A47/A11 Thickthorn Junction

Scheme Number: TR010037

SCOPING OPINION:

Proposed A47/A11 Thickthorn Junction

Figure Title	Drawing number
Figure 1.1 – Site Location	HE551492-GTY-EGN-000-DR-LX-30001 P02

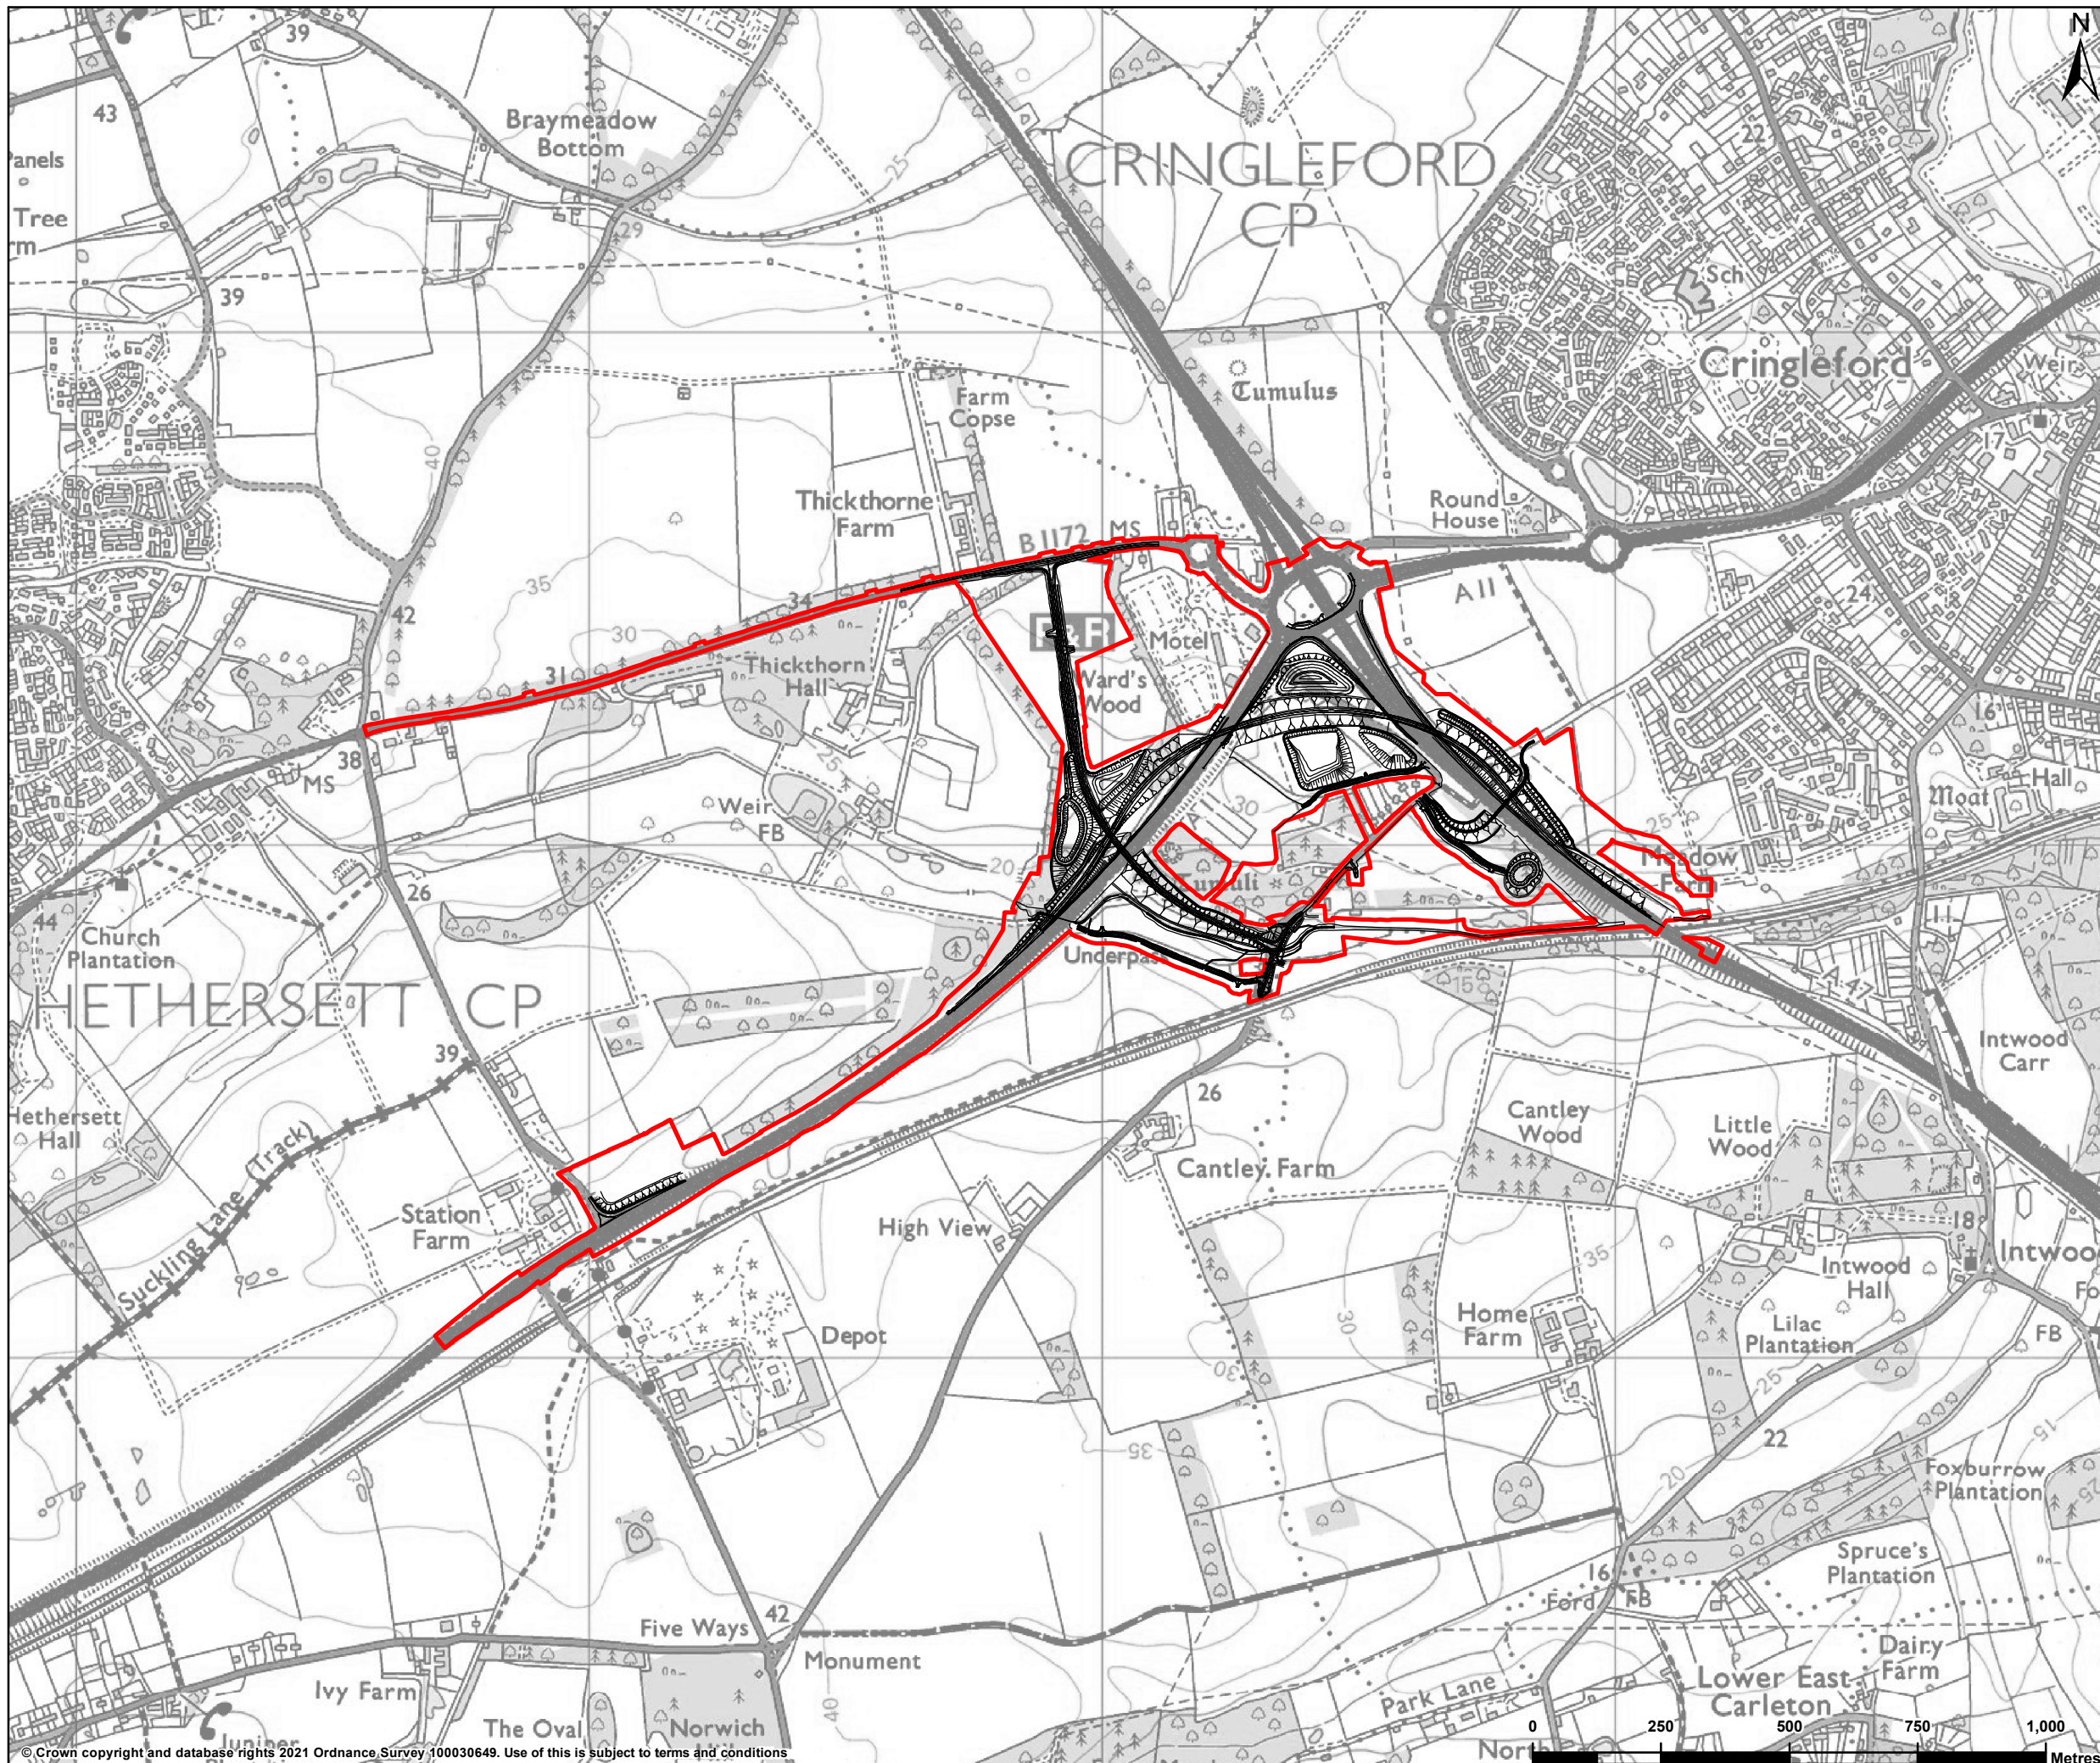
2.3.1 The Scoping Report contains only limited detail, with the main characteristics of the Proposed Development explained in high-level terms. The description of the Proposed Development is unclear and not consistent with what is shown on Figure 1.1 of the Scoping Report. For example, the description provides for two options for the side road strategy (to reconnect Cantley Lane South) and states that these options are collectively referred to as the 'Proposed Scheme', however neither option is presented on Figure 1.1. The description provided omits the other elements of the Proposed Development, such as, for example, the interchange link roads. The information provided on the link roads lacks detail and is confusing.

- 2.3.4 The legend in Figures 1.1 and 3.1 refer to 'Highways England led improvements' (shown in orange) and 'Proposed developer funded improvements' (shown in blue). A footnote included in Figure 3.1, but not in Figure 1.1, states that the development marked in blue is 'a local scheme progressed by developers with South Norfolk District Council'. This suggests that these elements are not included in the DCO application. However the land required for their construction is clearly included in the DCO site boundary (Figure A.1, Appendix A). This further confuses the understanding of what constitutes the Proposed Development.

- 2.3.5 The Inspectorate expects that at the point of application the ES should include a detailed description of the Proposed Development which includes all of the works for which development consent is sought, supported by clear figures. Details of components such as underpass structures, signage, gantries, lighting, drainage features, landscaping and environmental mitigation features have not been provided in the Scoping Report and this information should be provided in the ES.
